**Alexandria Park
Community School**
7-11 Park Road, Alexandria

**Architectural
and
Urban Design**
Response to Submissions

Prepared for
NSW Department of Education

April 2018 | Issue C

AR.DA. 5002

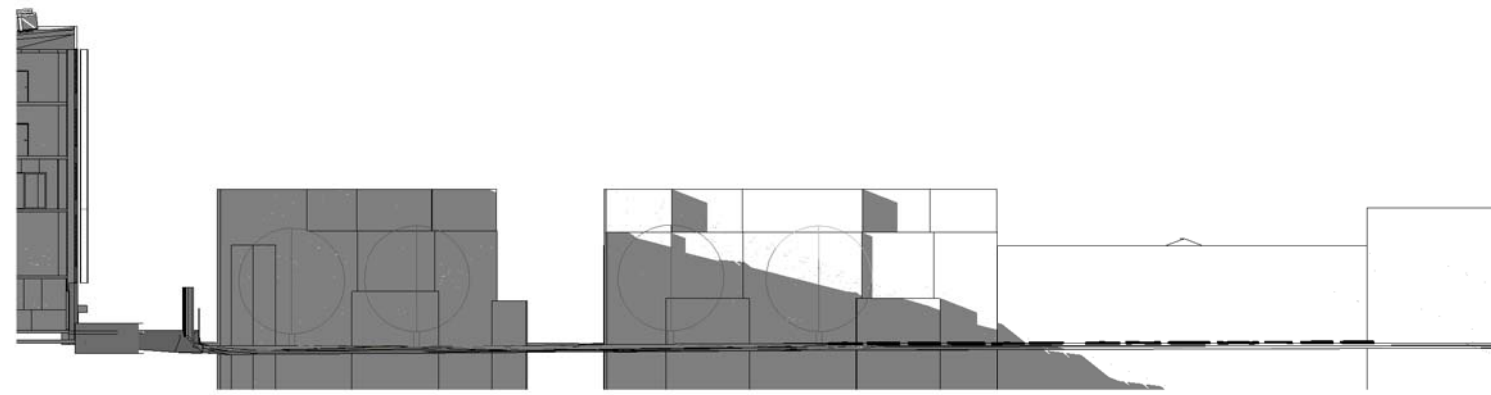
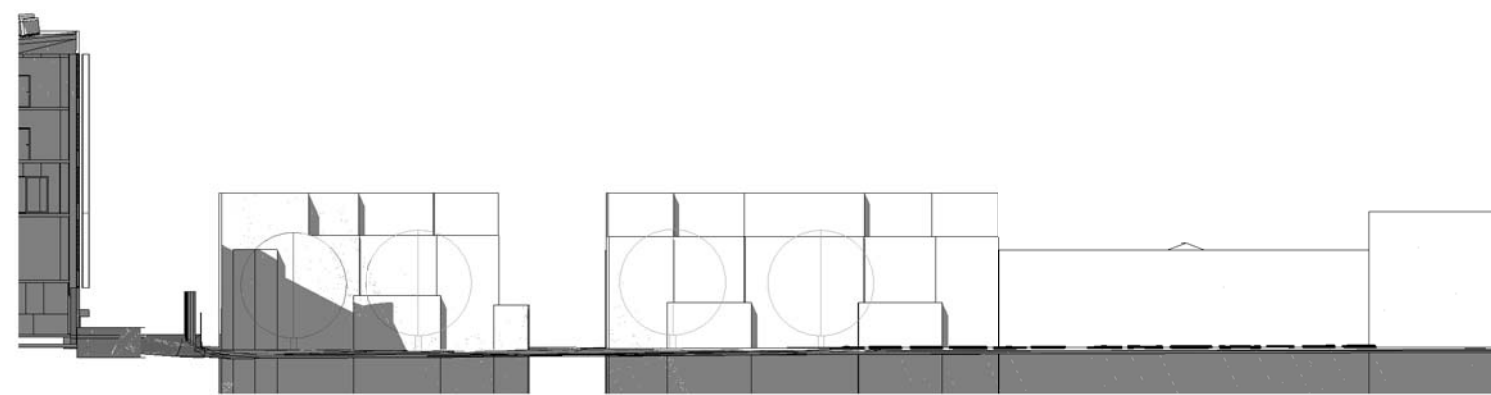
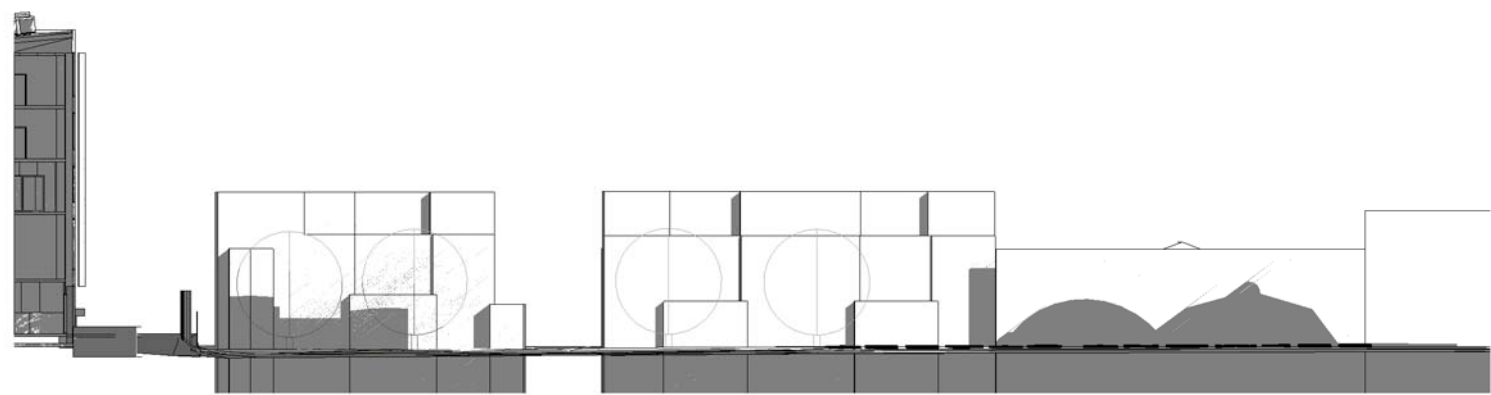
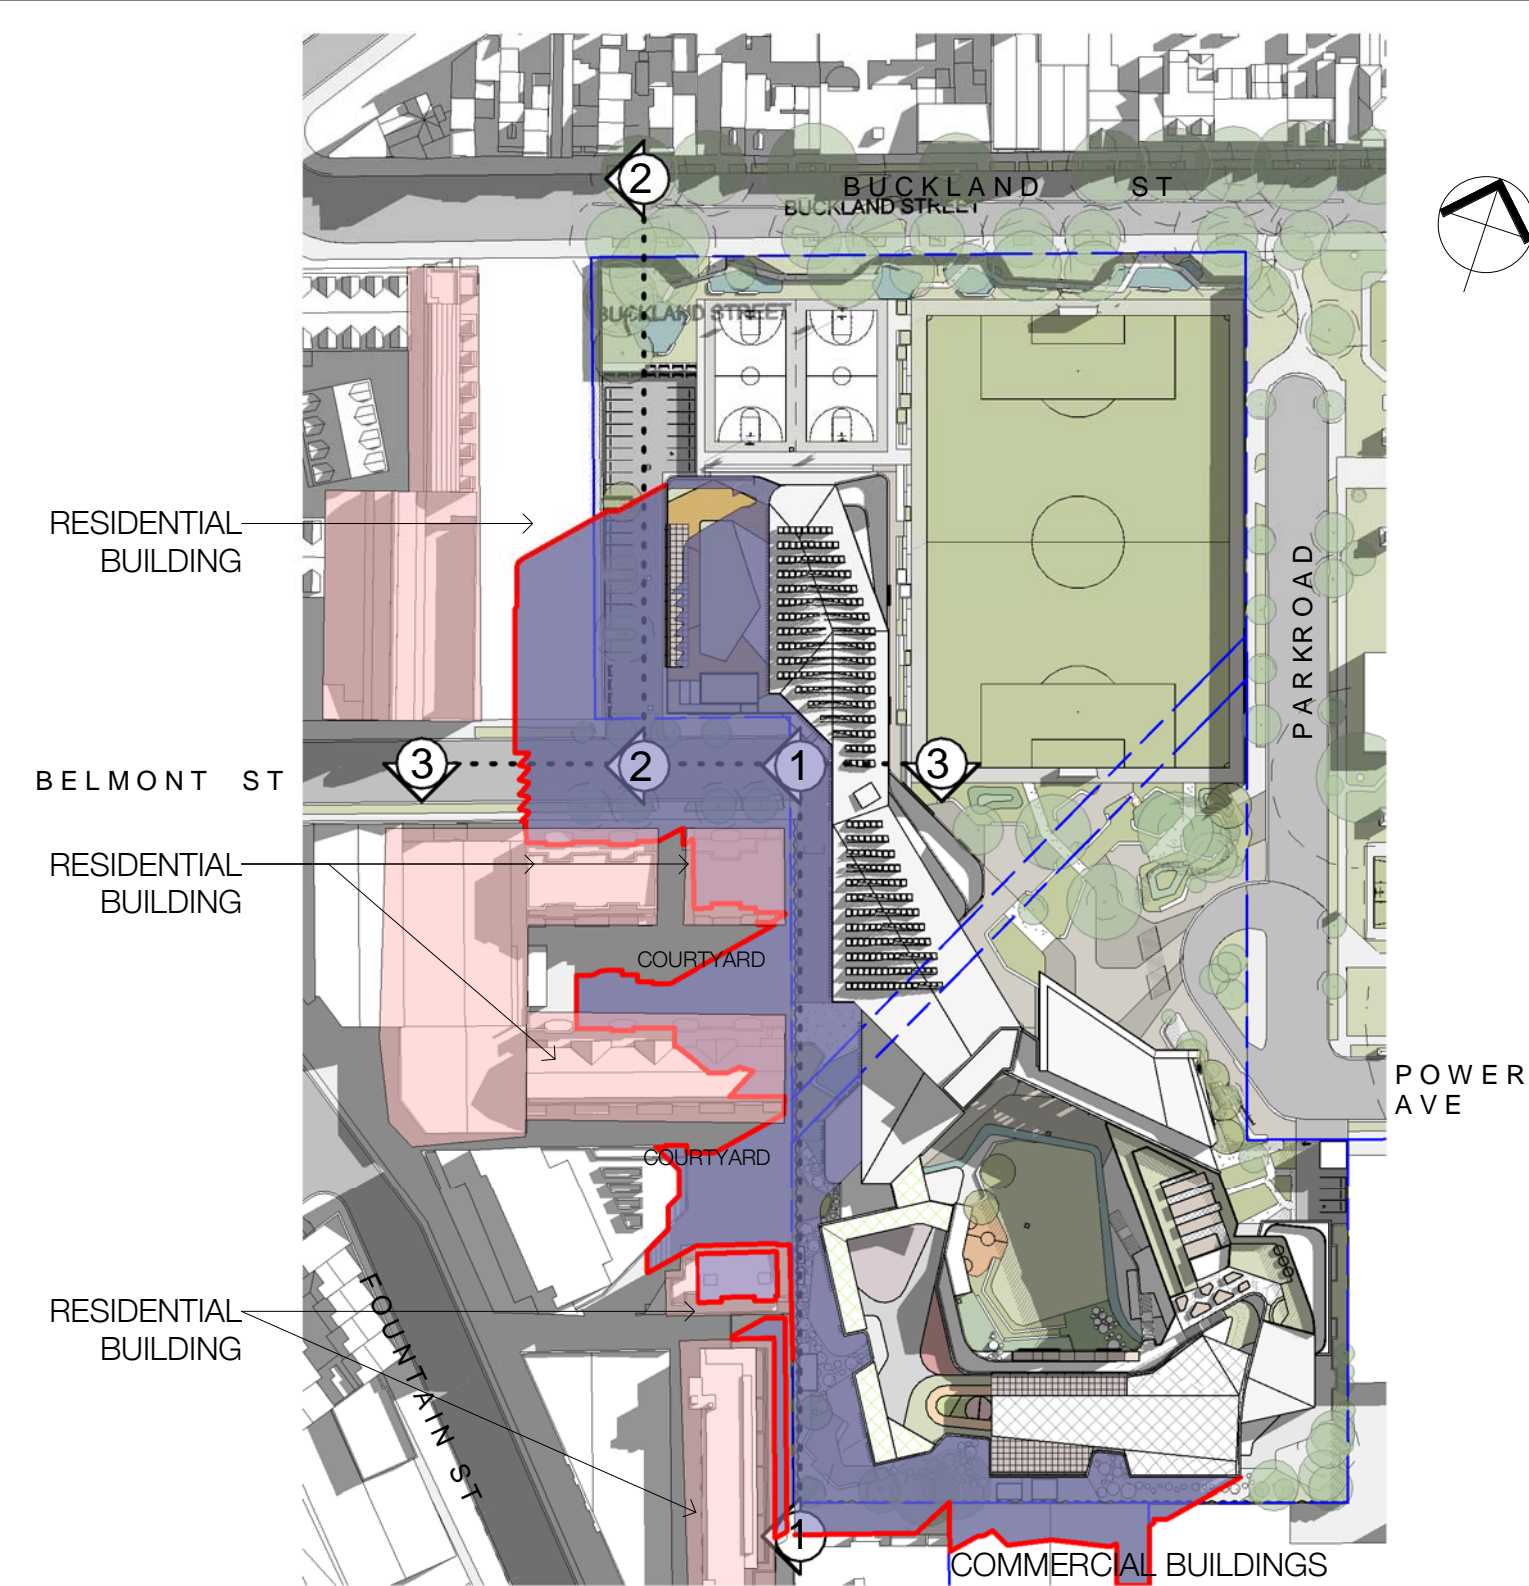
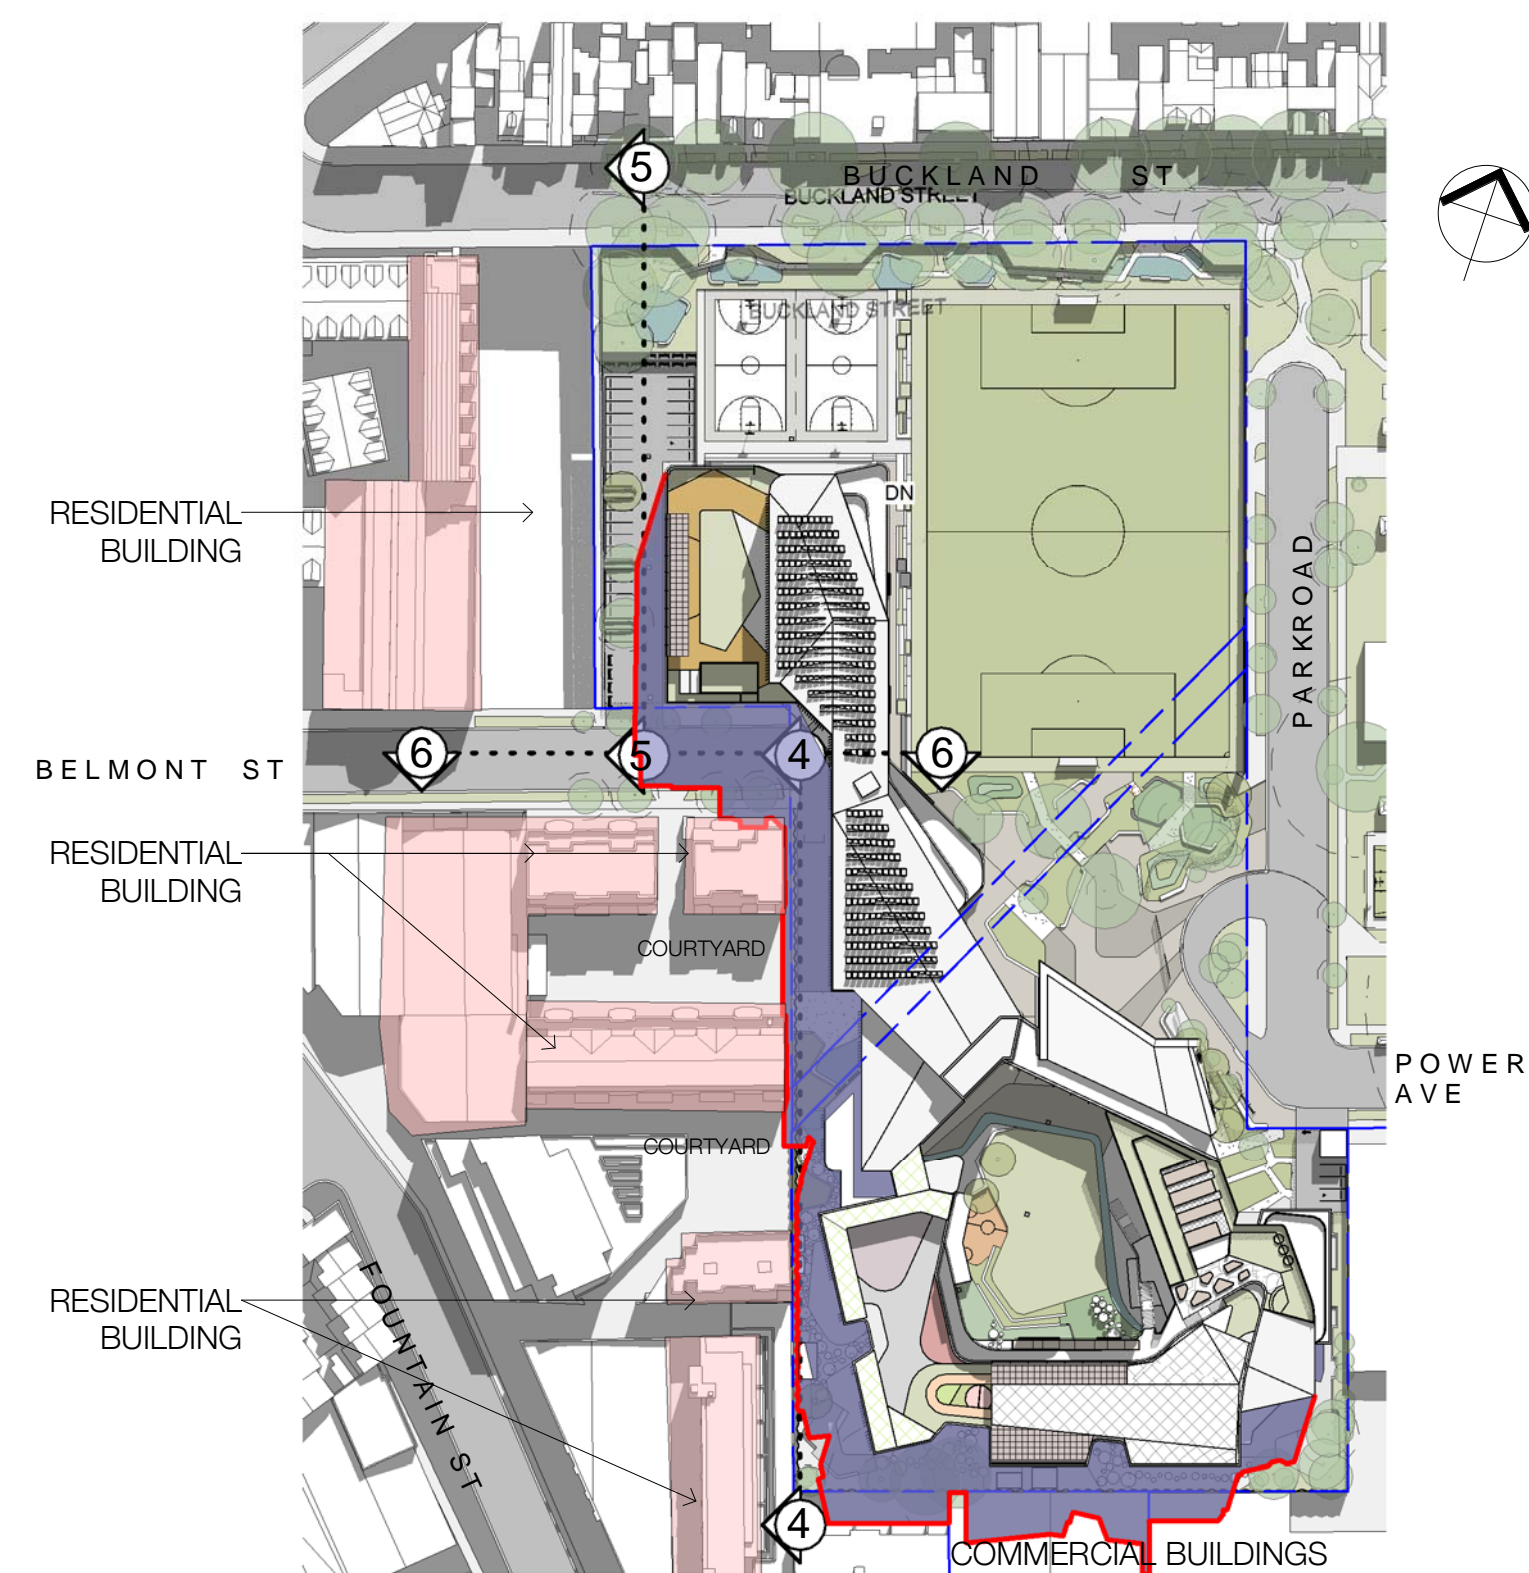
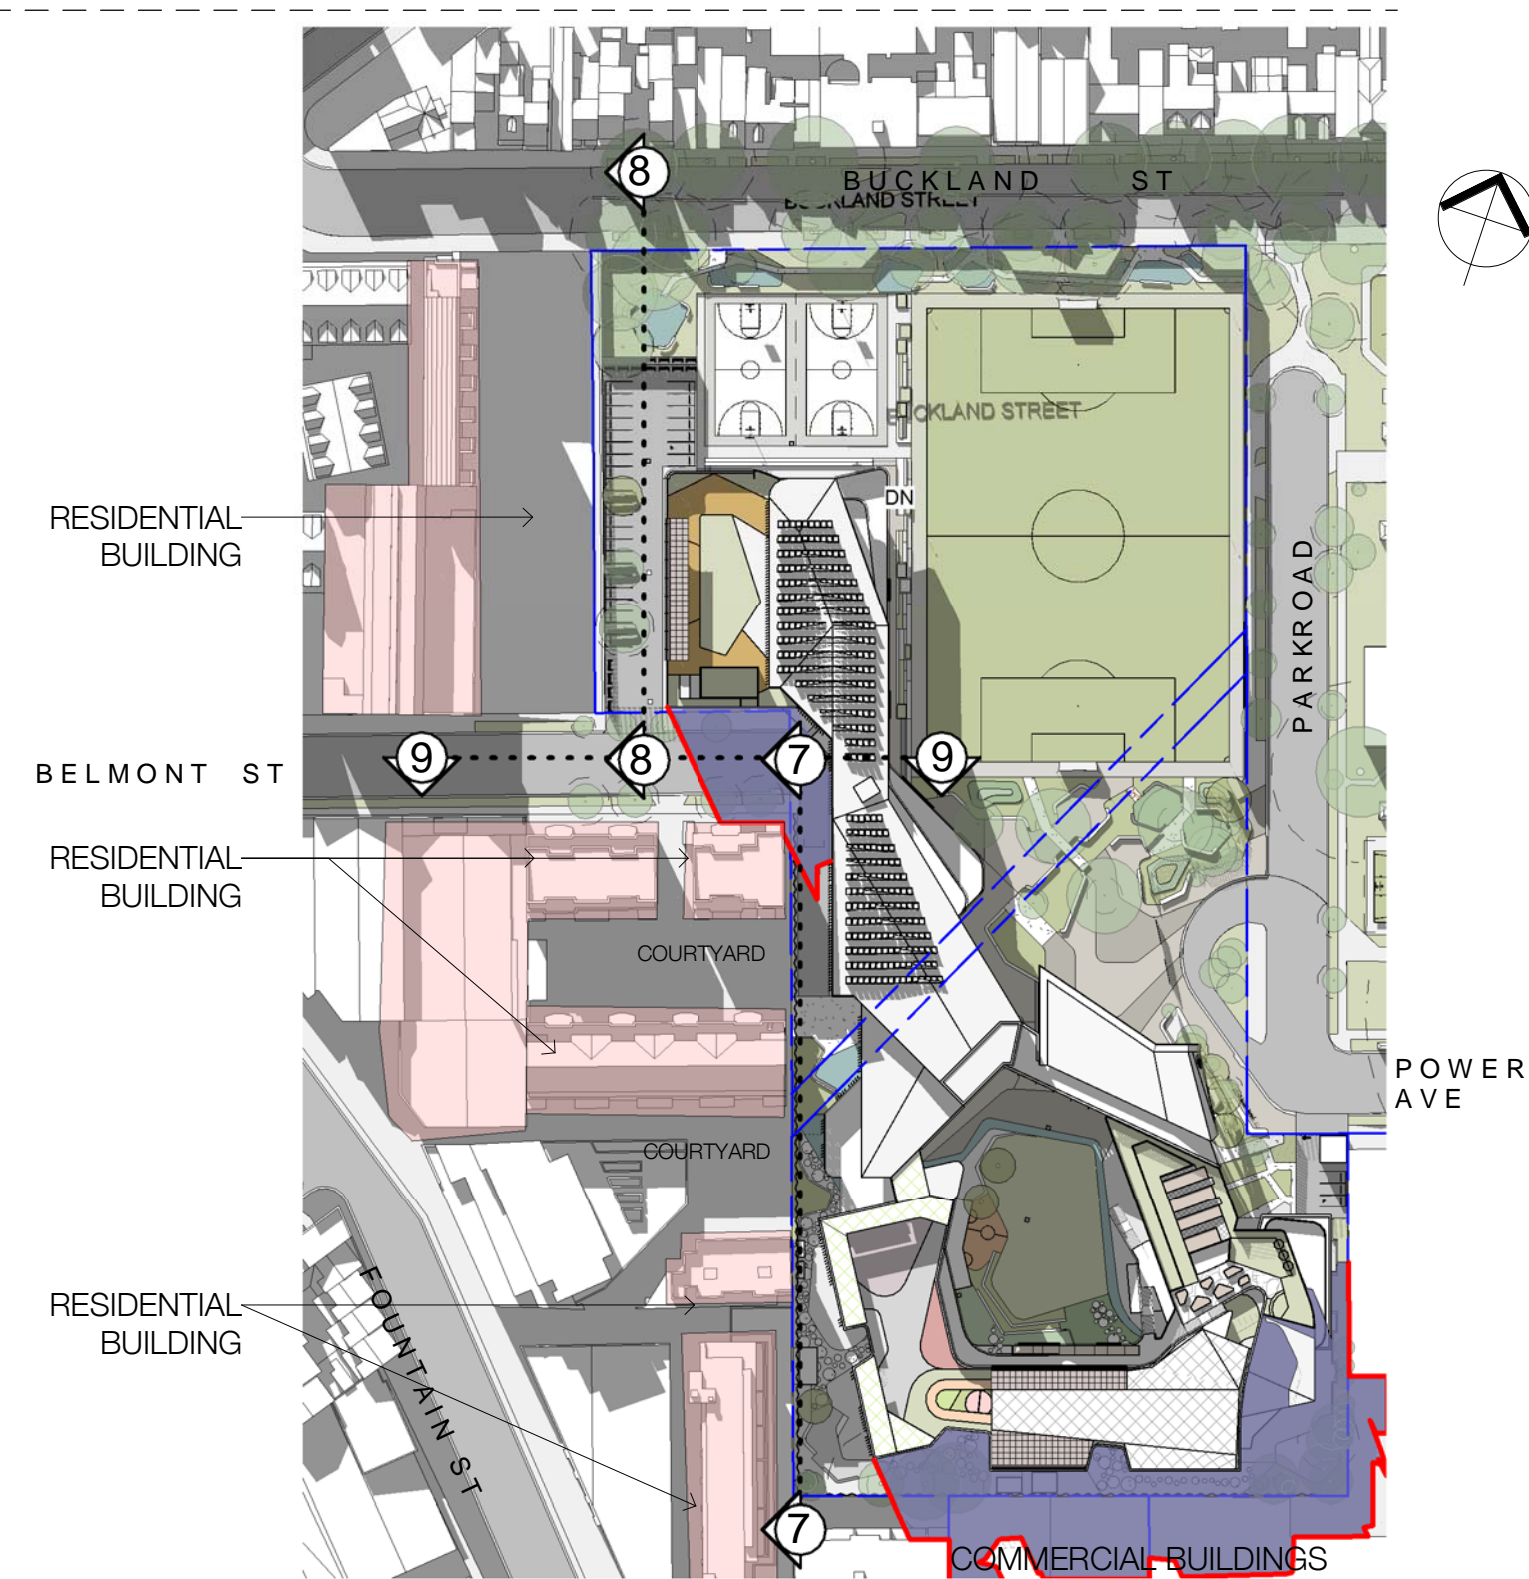
Further analysis of the shadow impact has focused on the residential developments to the west and south of the school. This analysis has reviewed the amount of solar access available to key living spaces of developments during the midwinter solstice and has compared existing (pre-redevelopment), as submitted, a notional 'complying height' development and amended development profiles should this be necessary. The two key residential developments are 58-60 Belmont Street and 141-143 McEvoy Street. The more detailed analysis has shown that these residential developments were affected to such a degree that the submitted design required modification to ensure that adequate solar access would continue to be provided each development. Other developments were not affected.

Further analysis has been done to indicate the complying height plane of 15m in both sections and 3D views and these are now shown for each adjacent residential development along the western boundary of the school. These sections also shown the relationship of the existing condition, whether it is the existing 1982 school building or the temporary demountable school buildings from 2017/18.
